Fire Marshal Division

Re: Good Hope Addition
410 Denim Dr.
Erwin, NC 28339

Application Number BCOM1906-0004

Thank you for submitting the sprinkler system plans for the Good Hope addition. The plans have been carefully reviewed by a qualified code enforcement official to examine for compliance with the North Carolina Fire Prevention Code and all other fire protection regulatory documents. There are some items that were found during the plan review process that need to be addressed before a final inspection of the new facility can be given. These items are outlined and described below.

SIAMESE FIRE DEPARTMENT CONNECTION (W) 6
NO SCALE

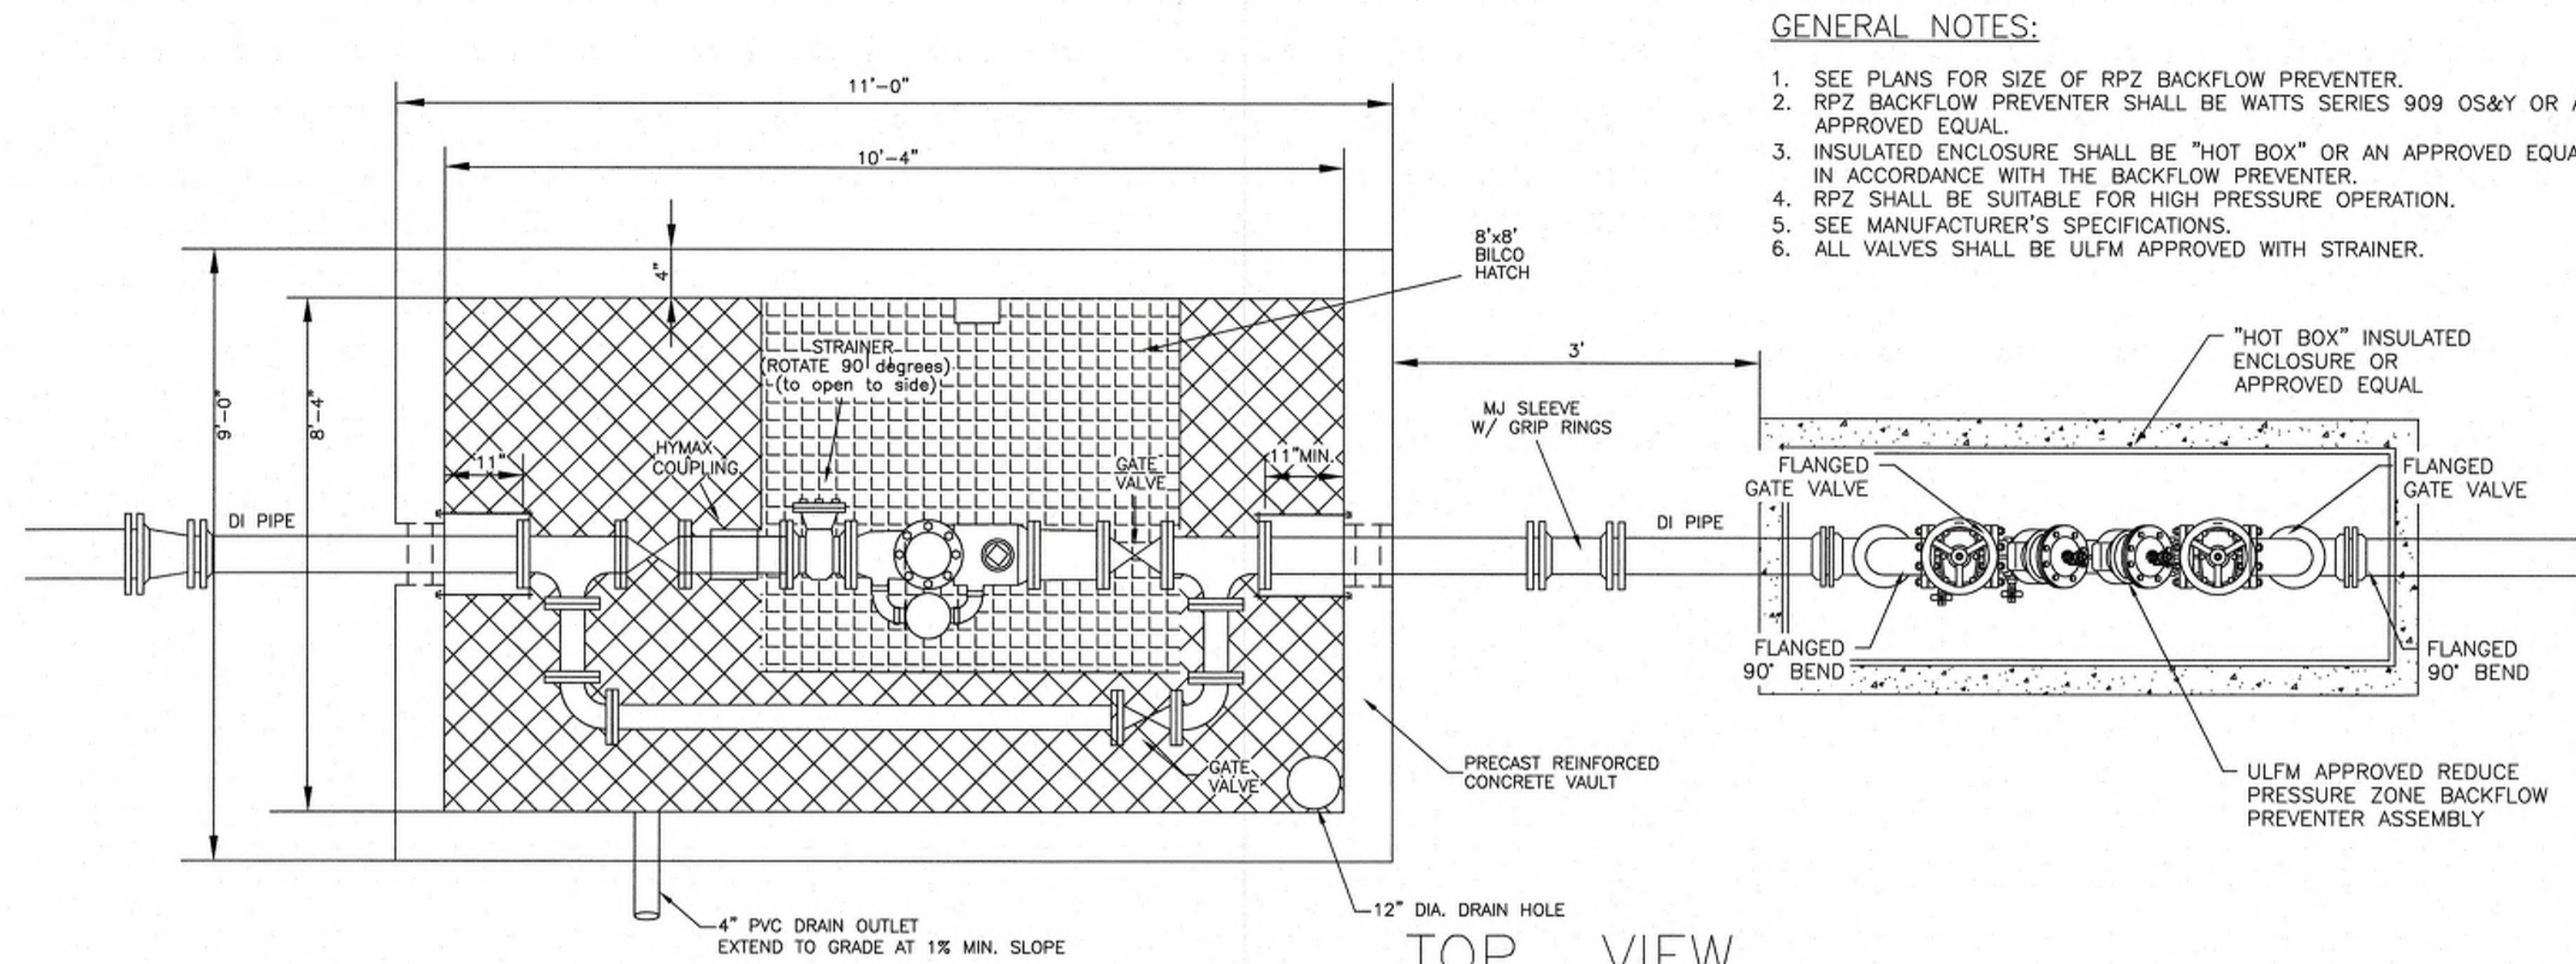
- **Plan Review Comments to Contractor.**
 - Installation of the sprinkler system shall be per contract specifications and NFPA 20013 edition.
 - Provide an FDC detail on the plans, also, the type and size indicated.
 - Provide hydraulic design data plate, spare sprinklers and wrench cabinet, and approved signage at final inspection per NFPA 13.
- **Statement of Compliance.**
 - Before requesting final approval of the installation, where required by the fire code official, the installing contractor shall furnish a written statement to the fire code official that the subject fire protection system has been installed in accordance with the manufacturer's specifications and the appropriate installation standard. Any deviations from the design standards shall be noted and copies of the approvals for such deviations shall be attached to the written statement.
